ARUN  
DISTRICT COUNCIL

Further to our telephone conversation yesterday and your request to move plot 1 even further from the RPZ we attach plans showing exactly what you want, i.e. a separation distance of 5.75m. Although we had written confirmation from Mr Vick that our last scheme was acceptable to him and Mr Warwick, we have made these further changes in good faith as you had been away when the previous plans had been agreed and they will at least allow a prompt decision to be made with no further delay.

Further to our conversation this morning Plot 1 has been reduced in width and some slight amendments made to the internal layout. (New floor area is 82.3 sqm)

Rev H 12/02/20 Plot 1 reduced in width.

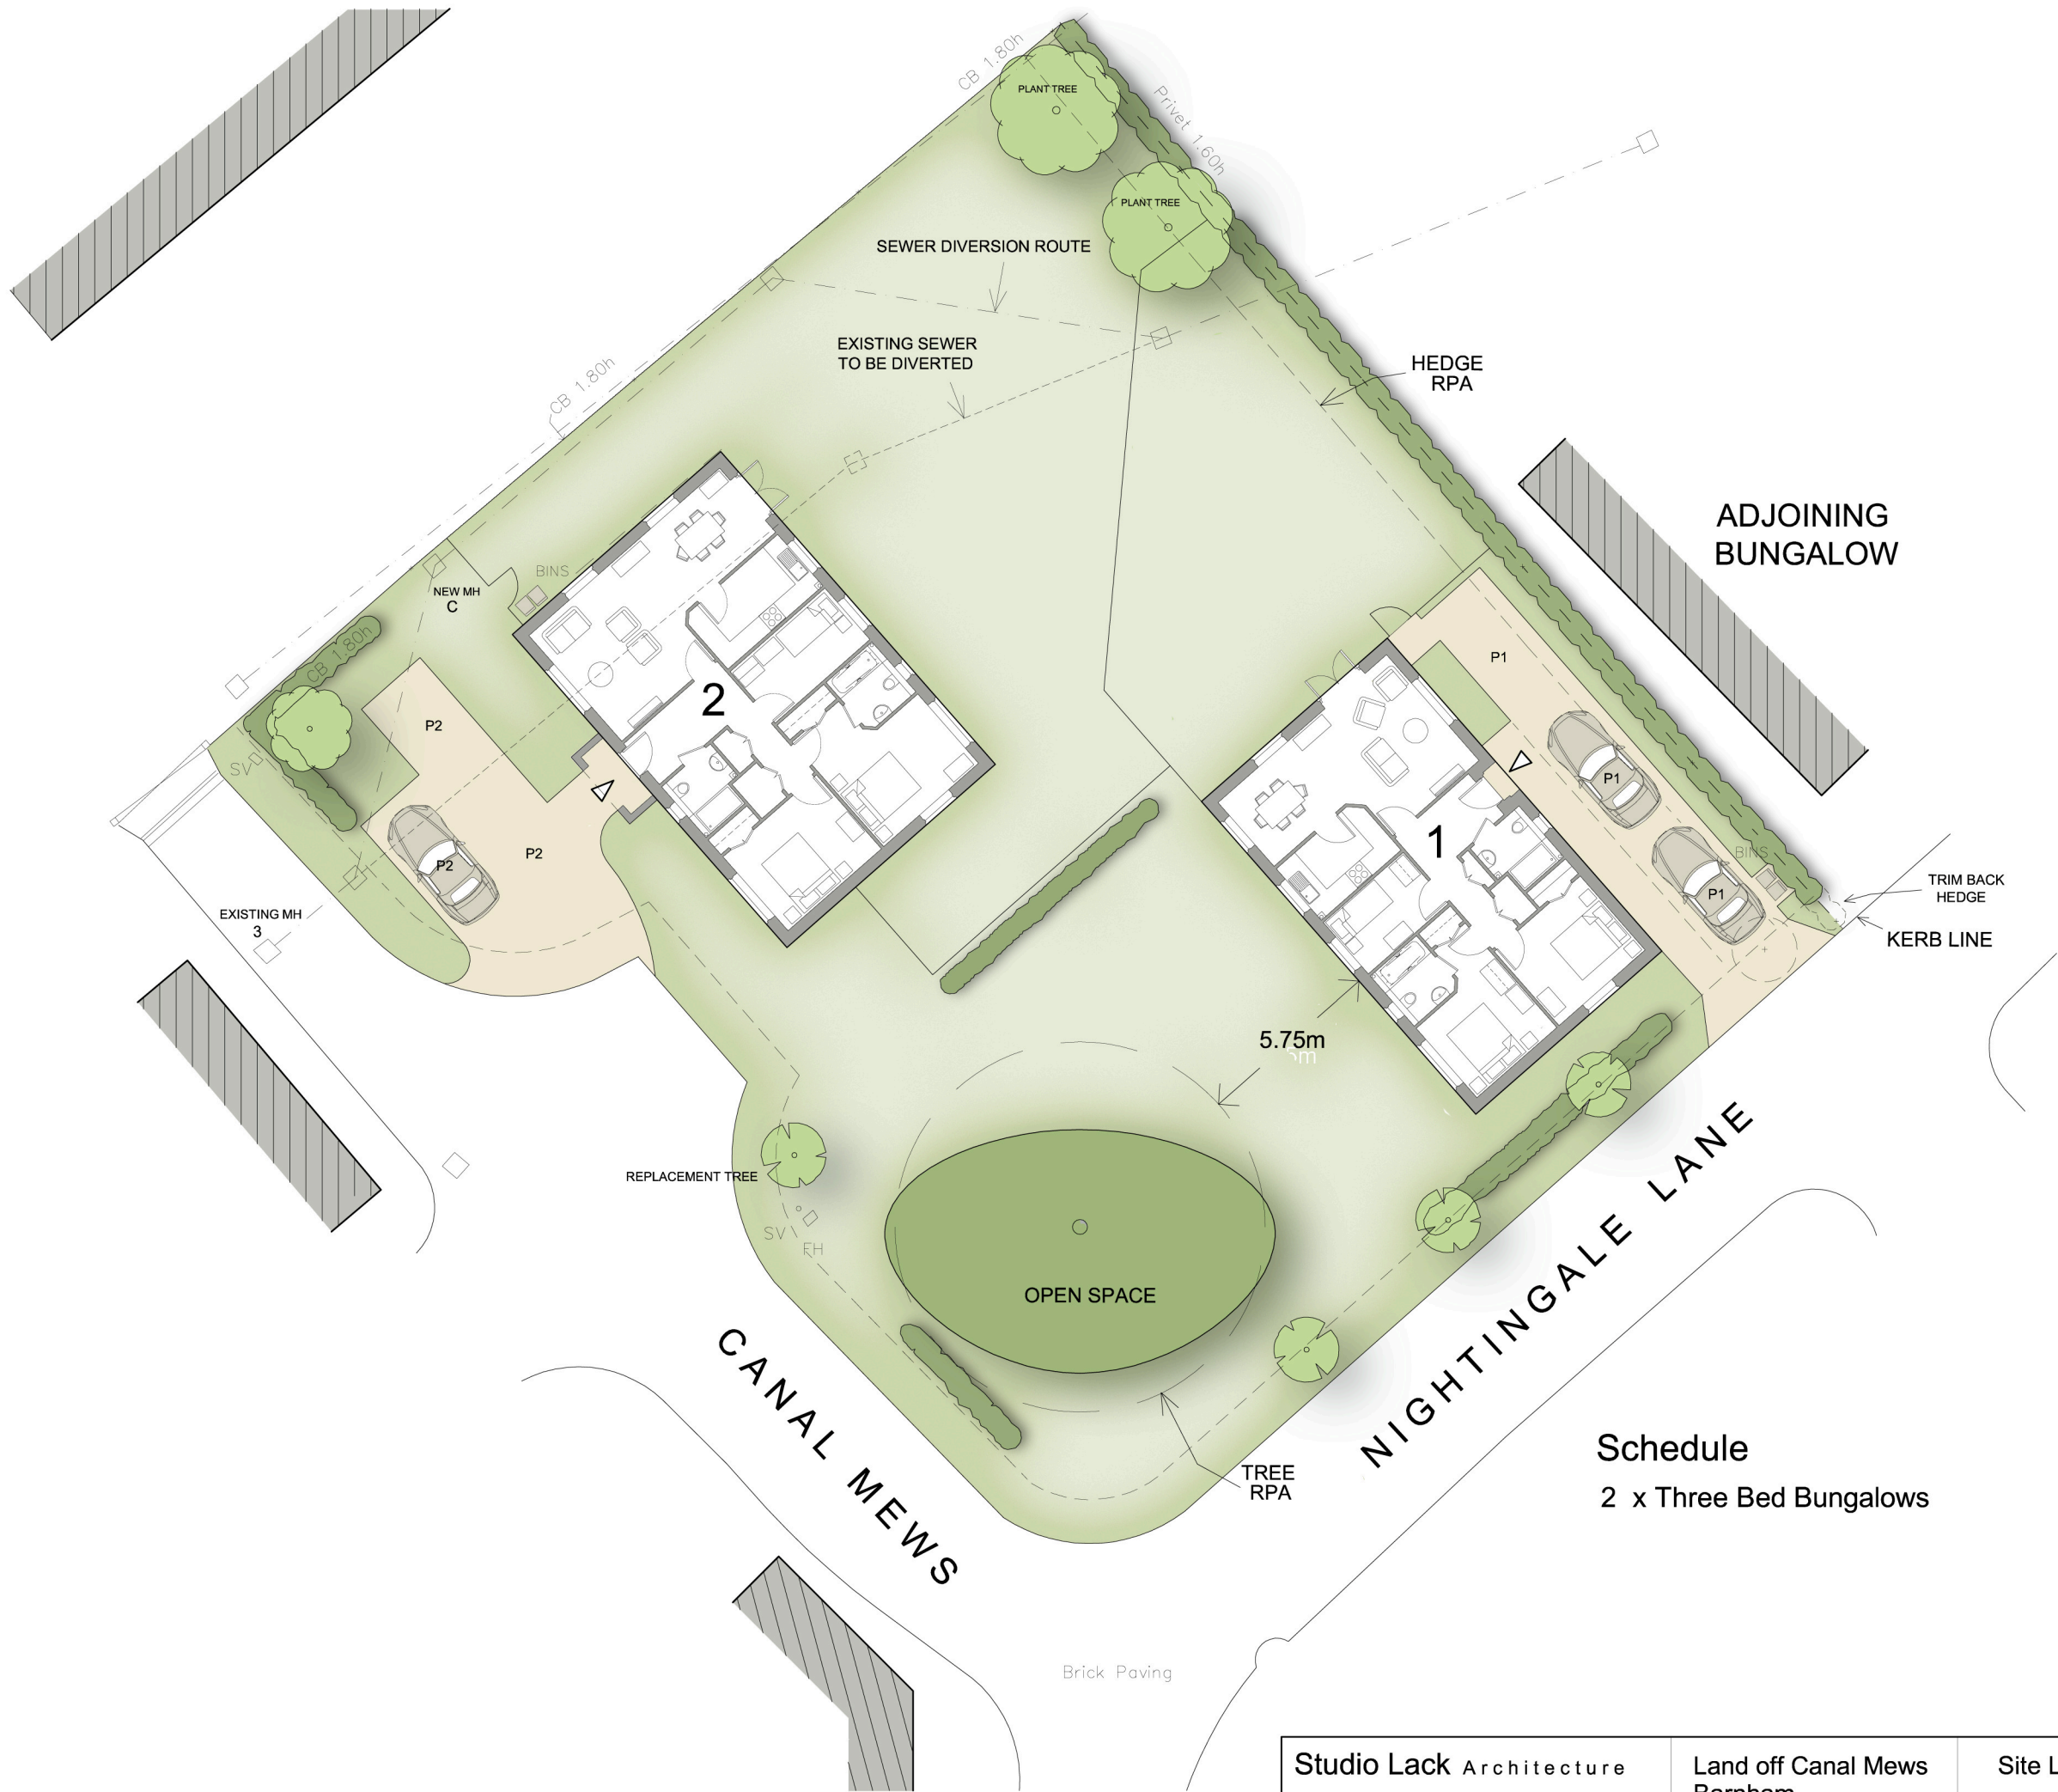
This has allowed us to move further away from the RPA which now measures 5.75m as the Planning Officer requested.
